WEST SUSSEX COUNTY COUNCIL CONSULTATION

TO:	Arun District Council FAO: Anita Gardner
FROM:	Highways, WSCC
DATE:	07/04/2021
LOCATION:	Land at Downs Way and Heathfield Avenue, East Preston, BN16 1AB
SUBJECT:	A/46/21/OUT Outline application with all matters reserved for the erection of a pair of one and a half storey semi-detached dwellings with vehicular access, private amenity space & landscaping.
DATE OF SITE VISIT:	N/A
RECOMMENDATION:	Advice
S106 CONTRIBUTION TOTAL:	£N/A

Owner:	Mr Kostas Povilaitis		
Project:	Land at Downs Way, East Preston Pair of Semi-Detached Bungalows		
Component:	Proposed Site Plan		
Note:	Rev.	Plan-No.:	CBL-0820225-PS101
Scale:	1 : 200	Date:	18/02/2021

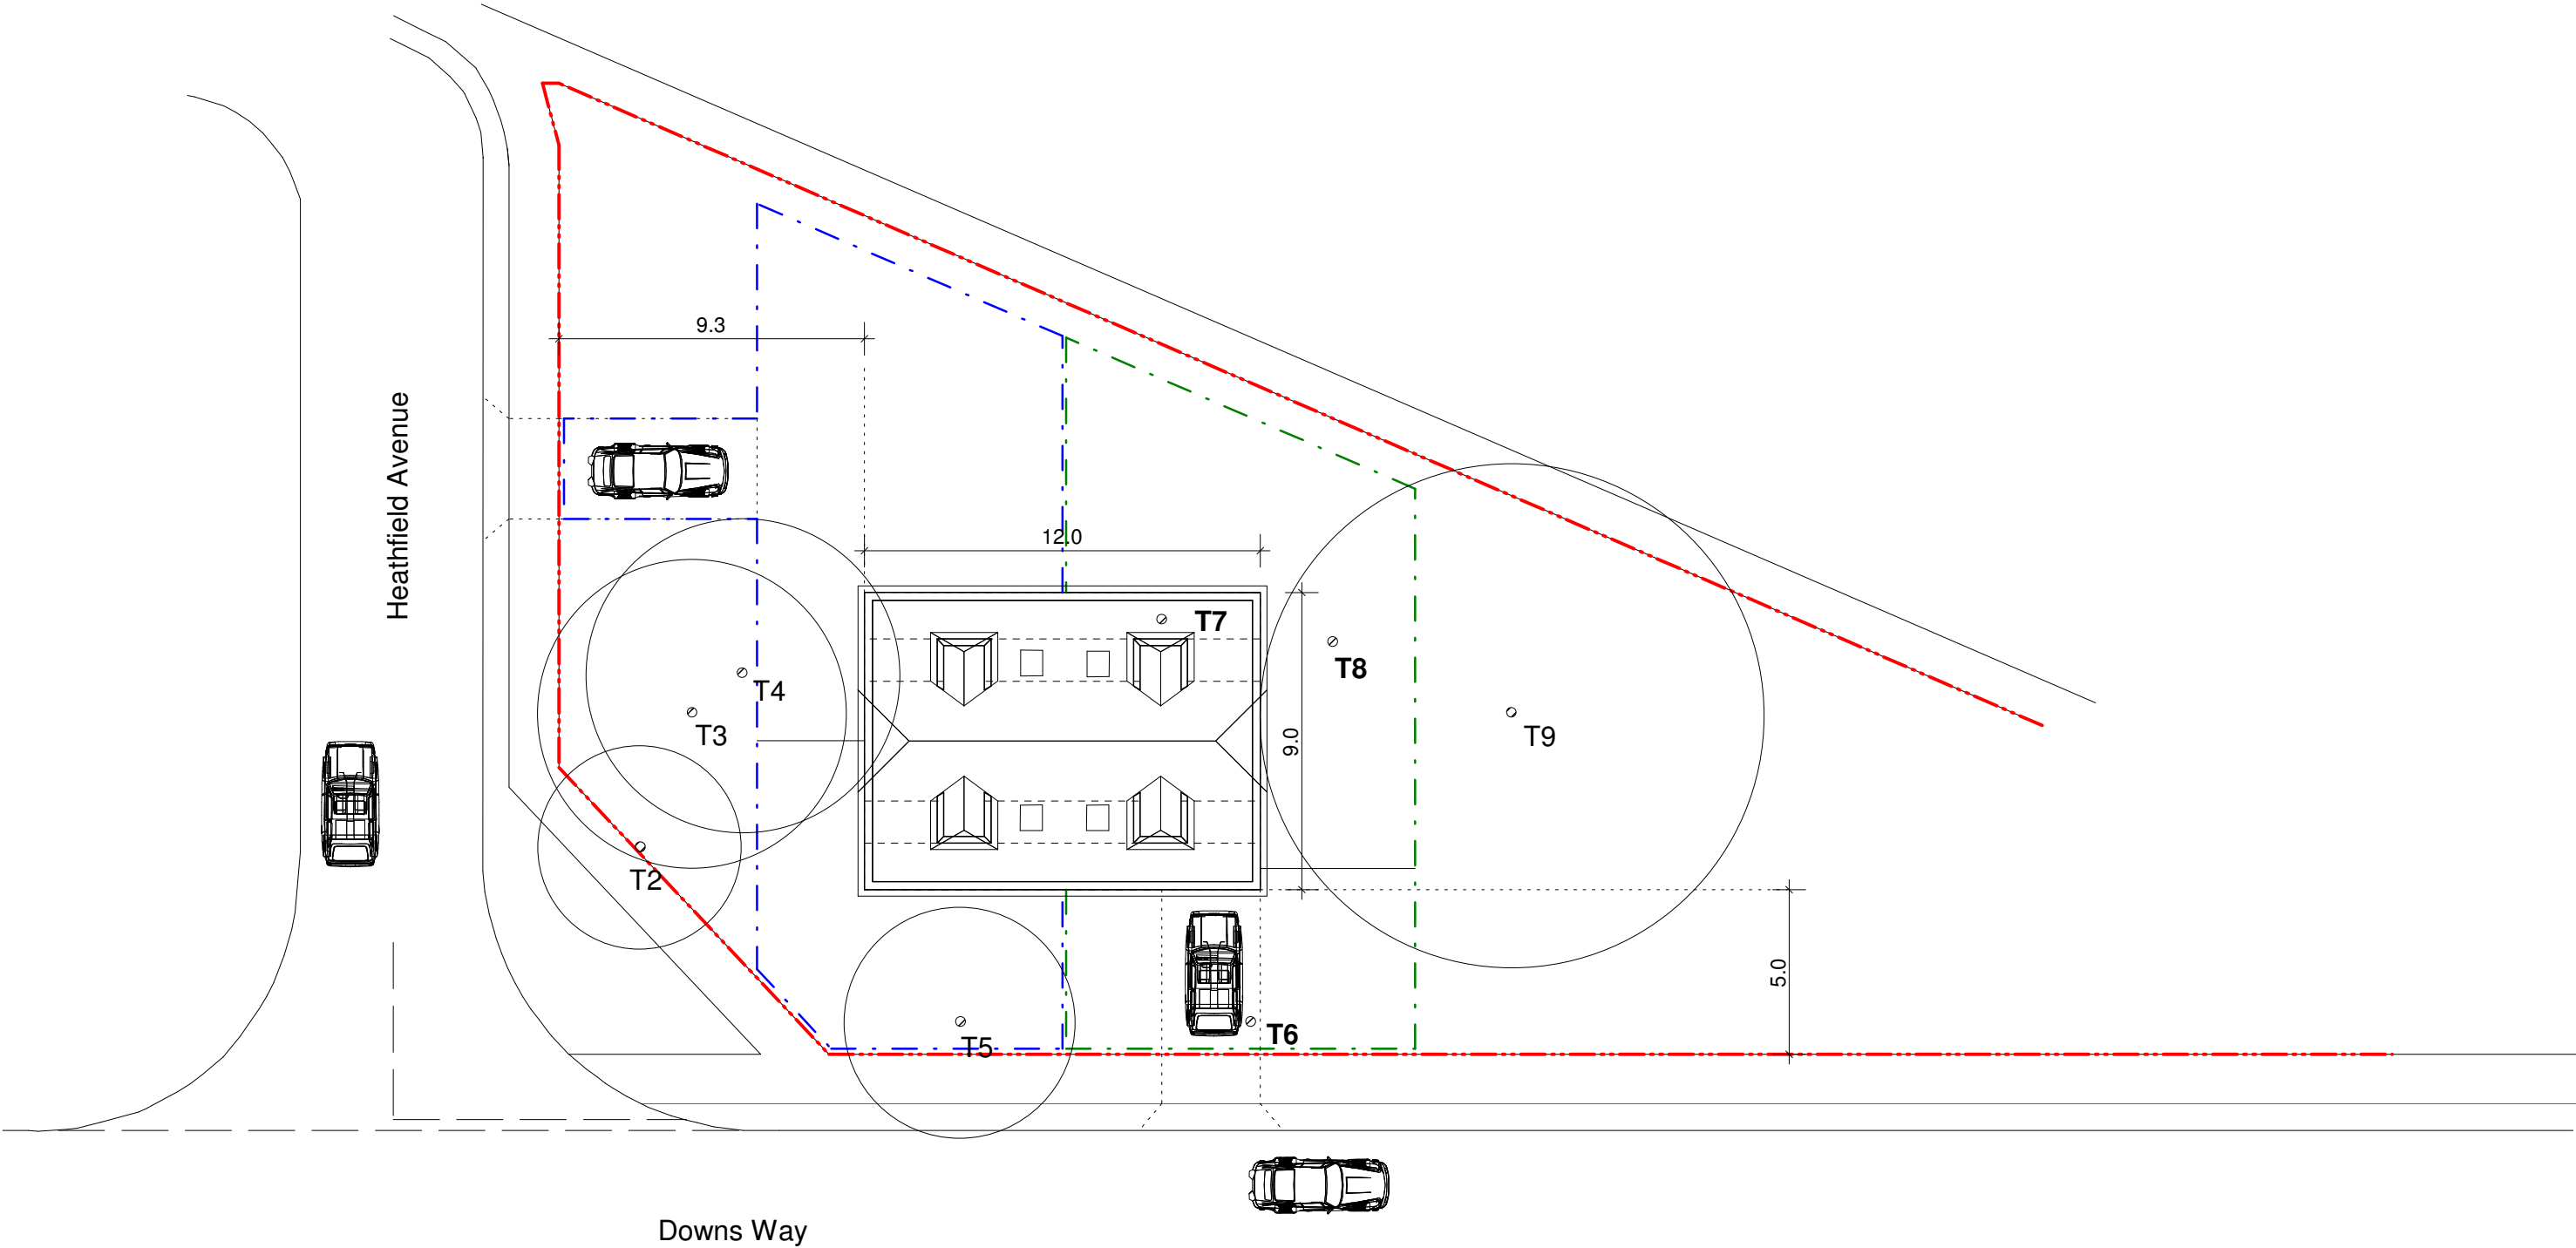
Details regarding access to the site would be expected at the reserved matters stage. The applicant has submitted an indicative site plan, suggesting vehicular access would be via both Downs Way and Heathfield Avenue. From inspection of local mapping, there are no apparent visibility issues with the indicative locations of access. New vehicle crossovers (VCO) are subject to a licence obtained through the local area office and would be constructed to a specification agreed with the local area engineer.

Using Local Mapping, it appears the whole site is classified as publicly maintained highway. For this land to be incorporated into the site, the highway rights need to be formally removed by way of a Stopping-Up Order. This is controlled by Section 247 of the Town and Country Planning Act and would be subject to a separate process administered by the Department for Transport's National Casework Team. The Highway Authority along with other statutory undertakers and interested parties would be consultees in this process. There is no guarantee that this process would be successful. The comments made here would not necessarily constitute the Highway Authority's formal position regarding any future stopping up.

Details regarding the proposed parking provision and turning layout should be demonstrated at reserved matters stage. Parking provision should be provided in accordance with Arun Parking Standards. For a development of this size, the LHA would expect a parking provision of at least four parking spaces. Parking bays must meet the minimum specifications for single car bays of 2.4m x 4.8m, and single-car garages of 3m x 6m. Demonstration of an ability to turn on-site would be beneficial, although the LHA would not anticipate that vehicles reversing onto the highway would be cause for a highway safety concern in this location.
